KITTITAS COUNTY COMMUNITY DEVELOPMENT SERVICES

Subject: New Suncadia, Phase 1, Division 15 (LPF-18-00006) Final Long Plat – Staff Review and Request for Additional Information

DATE : 2018-08-30 | JOB NO. 998-766-016-0002  
DRAWN BY: C.A.F./R.F.G. | SHEET 1 OF 5

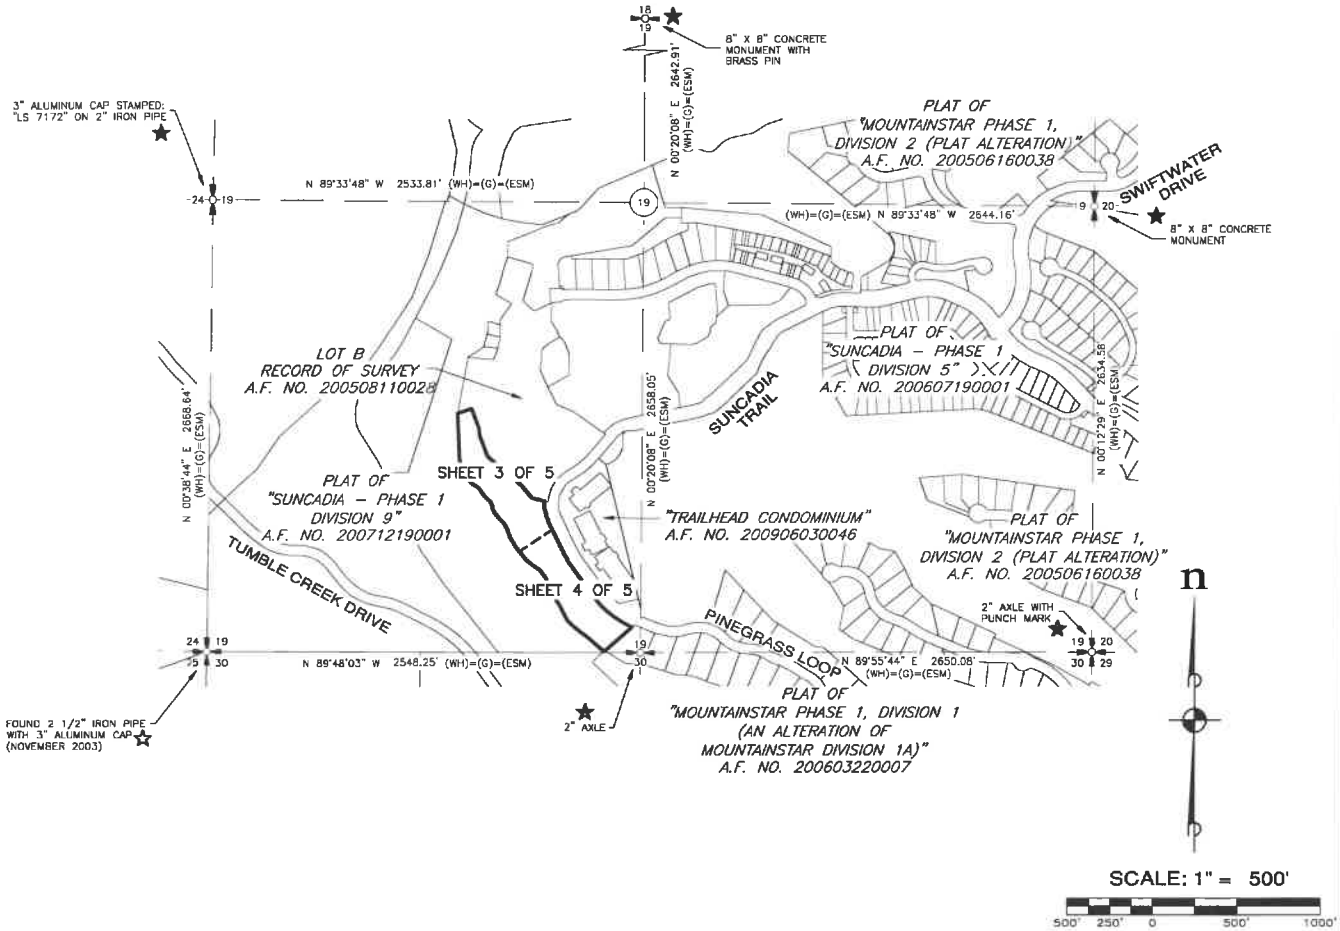
- Required Changes
 1. On sheet 1 the certificate is shown in two locations.
 2. Sheets 3 and 4 are missing the surveyor stamp.
 3. Suncadia Trail should include the ownership and surfacing (EX: Suncadia Trail, Private R/W-Paved).
 4. The additional R/W to be dedicated to Suncadia Trail should be labeled as “additional right of way herein dedicated.”
 5. Sheet 4 includes a legend item “Found corner as noted”. Please note what was found in the two locations containing this symbol.
